February 14, 2014

**Re: Office Addition, 1121 San Mateo Blvd NE, Traffic Circulation Layout
Engineer's Stamp dated 2-6-14 (J17-D034)**

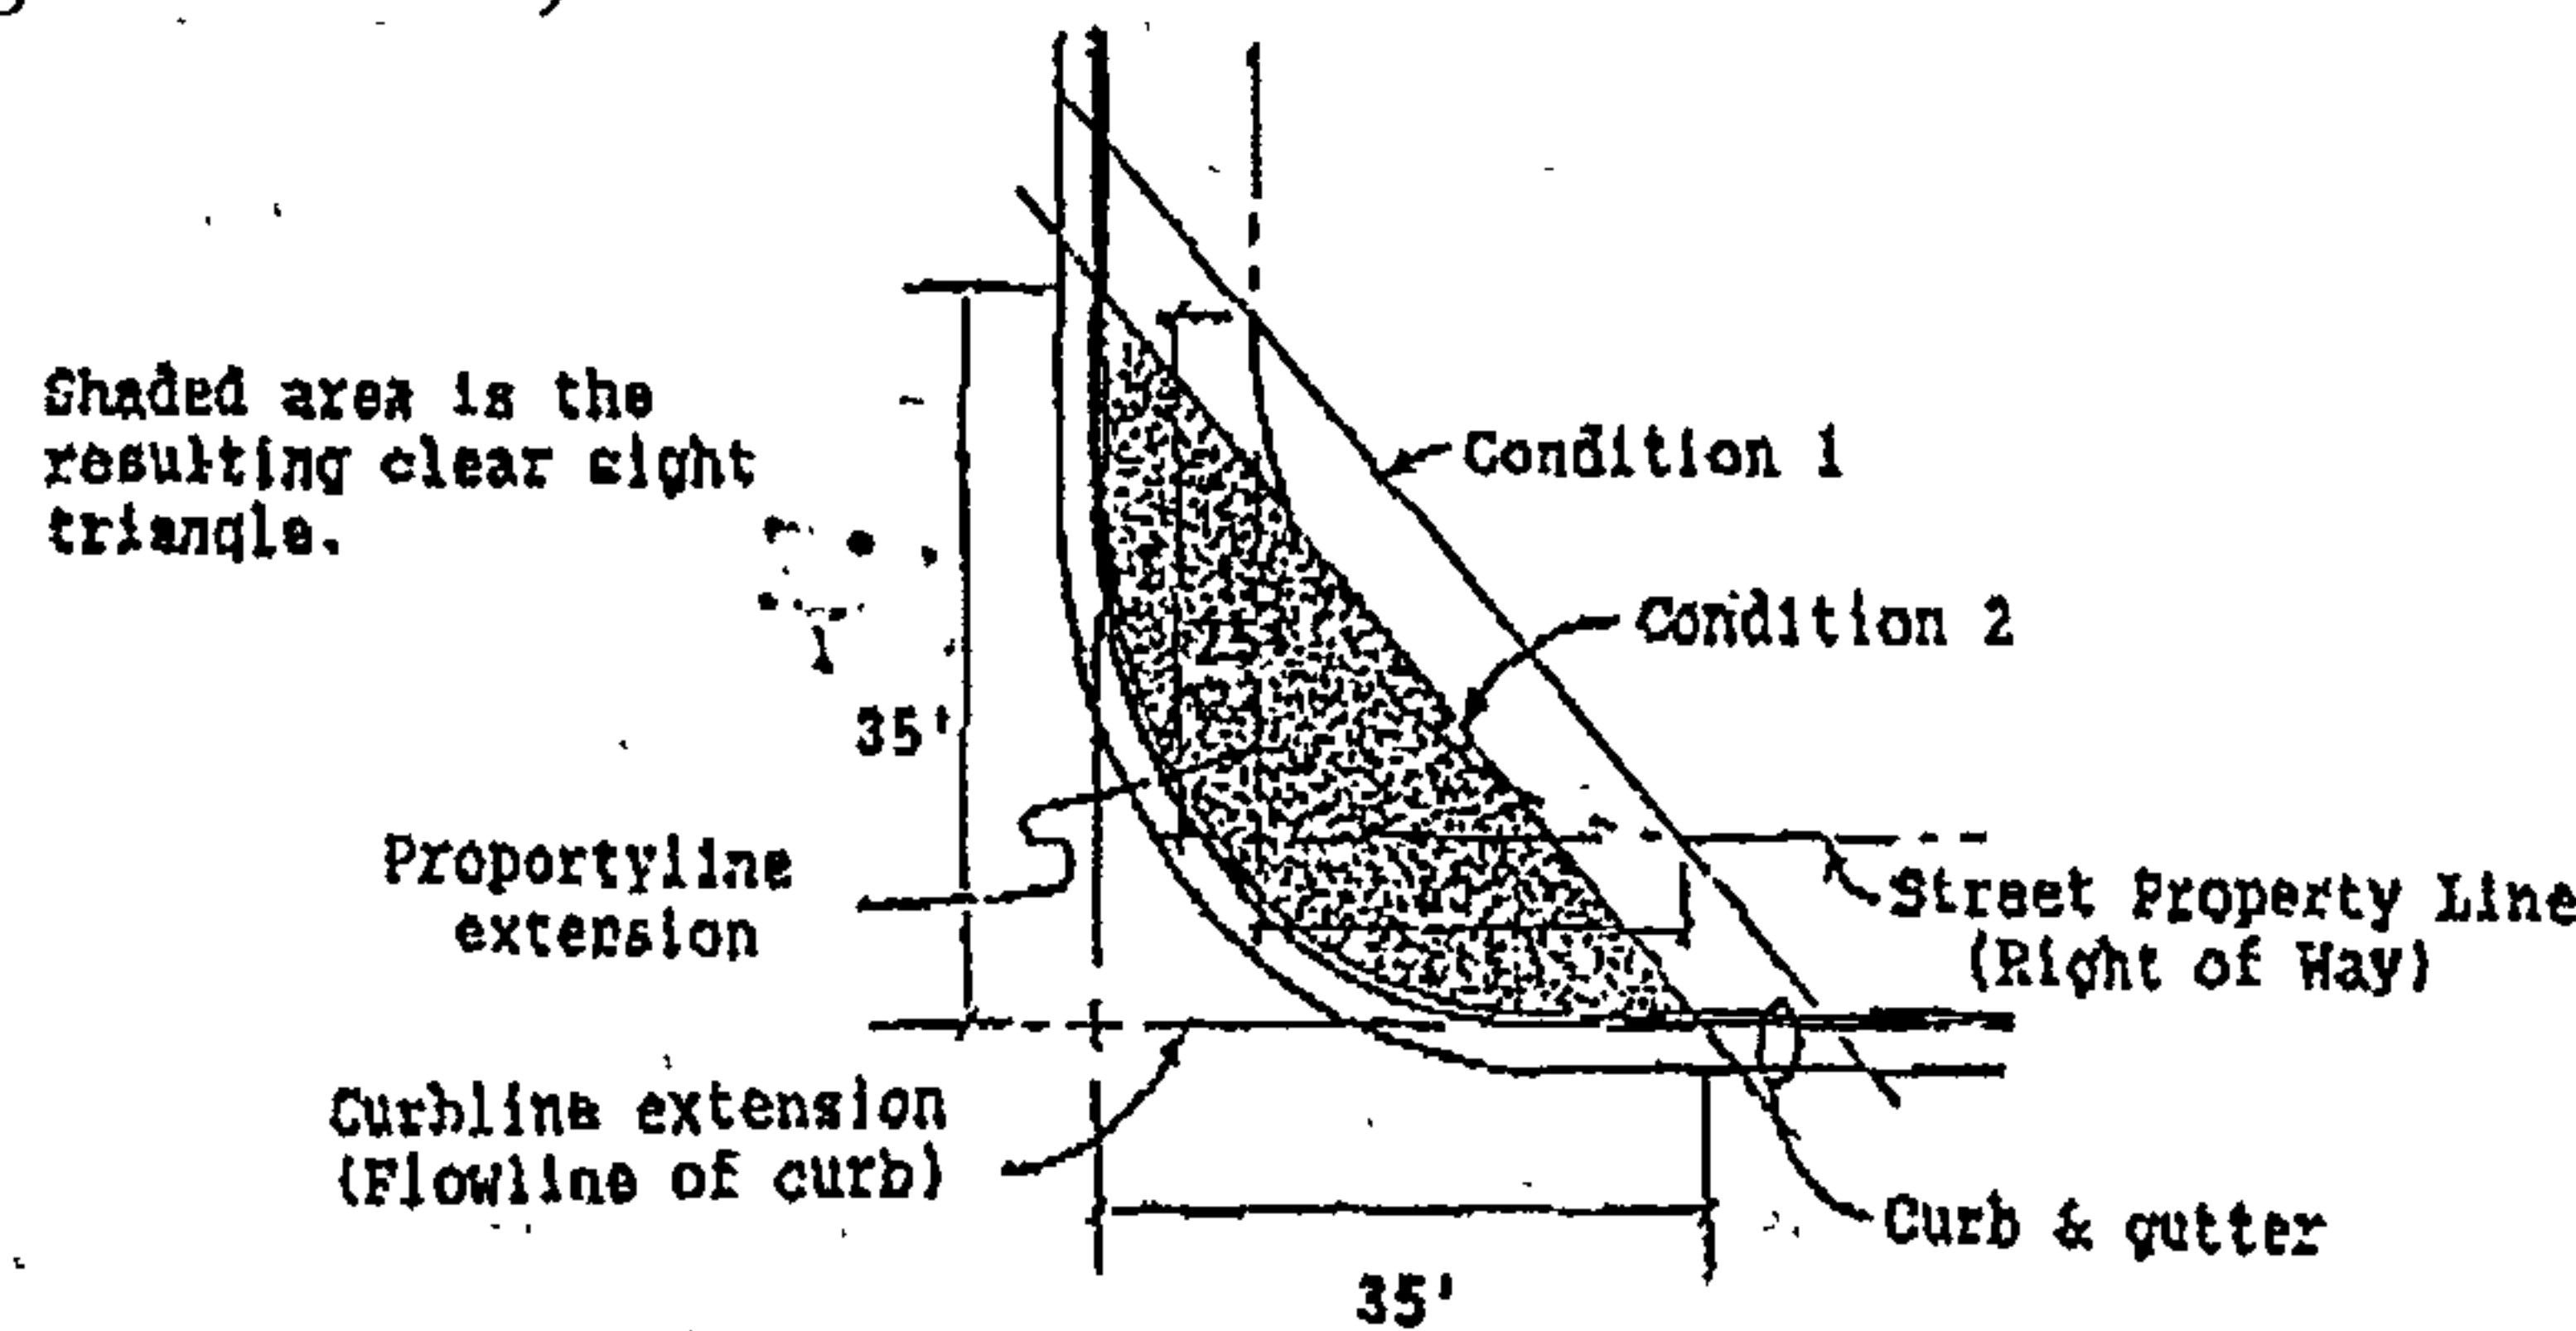
- Pre-existing parking within the COA ROW can remain as long as it is not touched, does not present a public safety issue, and is not in use by the City. This means, no adjustment to the striping, no addition of parking within the ROW and no restrictions by the owner over this strip of COA ROW.

- Request to have the alley paved per COA specifications for the full length of the property is retracted at this time. If the alley is used for vehicle access to and from the property, the section of alley used must be paved. A minimum of 20 feet must be paved to reduce dirt from entering the street.

- Refuse location and pickup appears to occur at every abutting development on this alley. The alley is a COA ROW and a request to move encumbrances from this alley is within the City's jurisdiction. However, as long as your development can provide an approved location within the property, the current location may continue until further notice.

- As discussed over the phone, the City requests the existing curb cut on San Mateo be amended to meet current ADA and DPM requirements. Please modify the driveway to provide a safe ADA compliant crossing.
